Your ref H09/0670/01
Our ref GRM/JJM/243/01

**PROPOSED SECURITY GATES
HOLBEACH UNITED SERVICES CLUB, CHURCH ST, HOLBEACH.**

PLANNING AMENDMENT

GATE DETAIL B
1/25

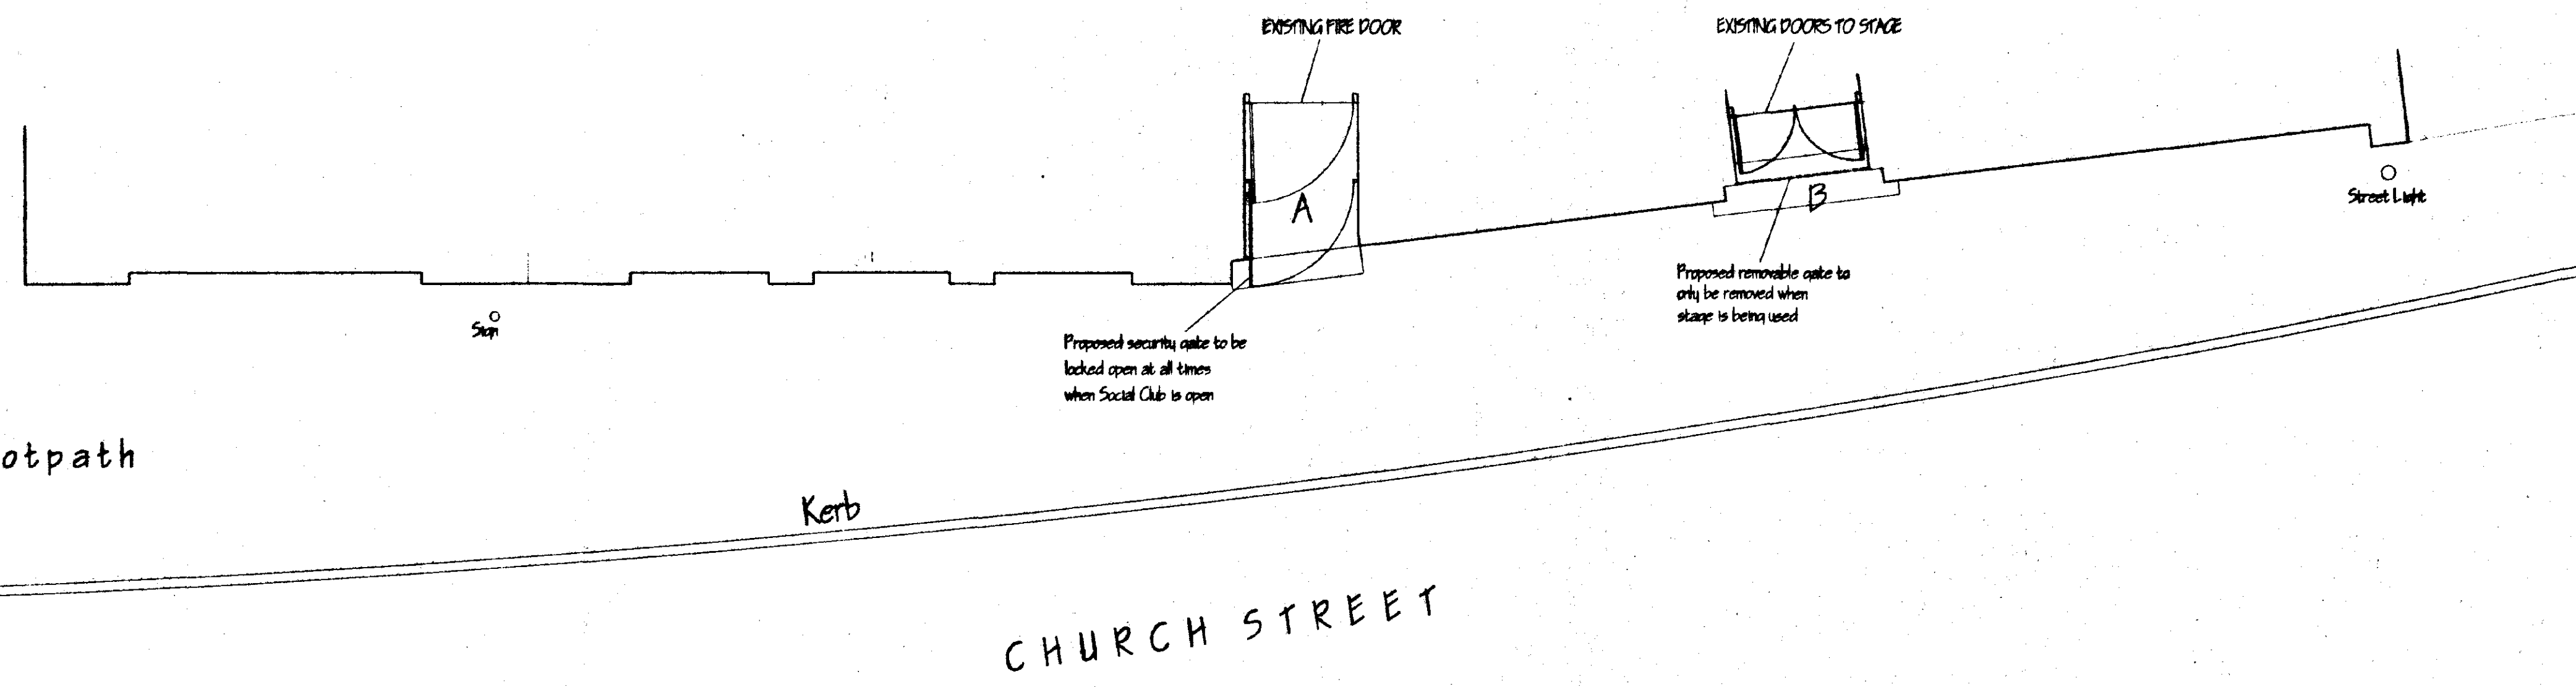
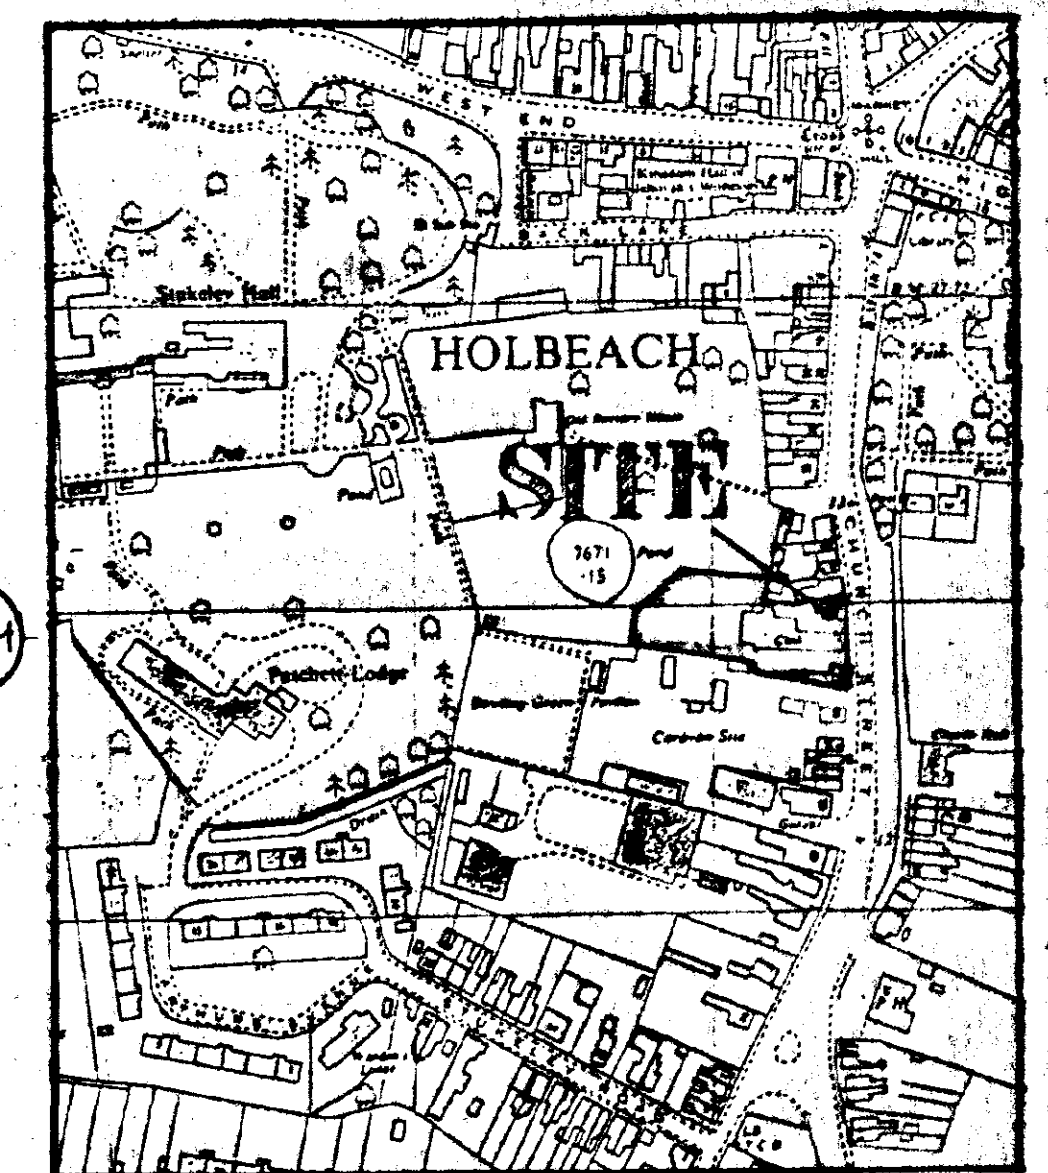
Further to our telephone conversation with respect to the above application, I confirm that the vertical bars on the proposed security gates will be a minimum of 14mm diameter as requested. Please find enclosed 2 no. copies of amended plans.

vertical Bars
will be minimum
of 14mm diameter
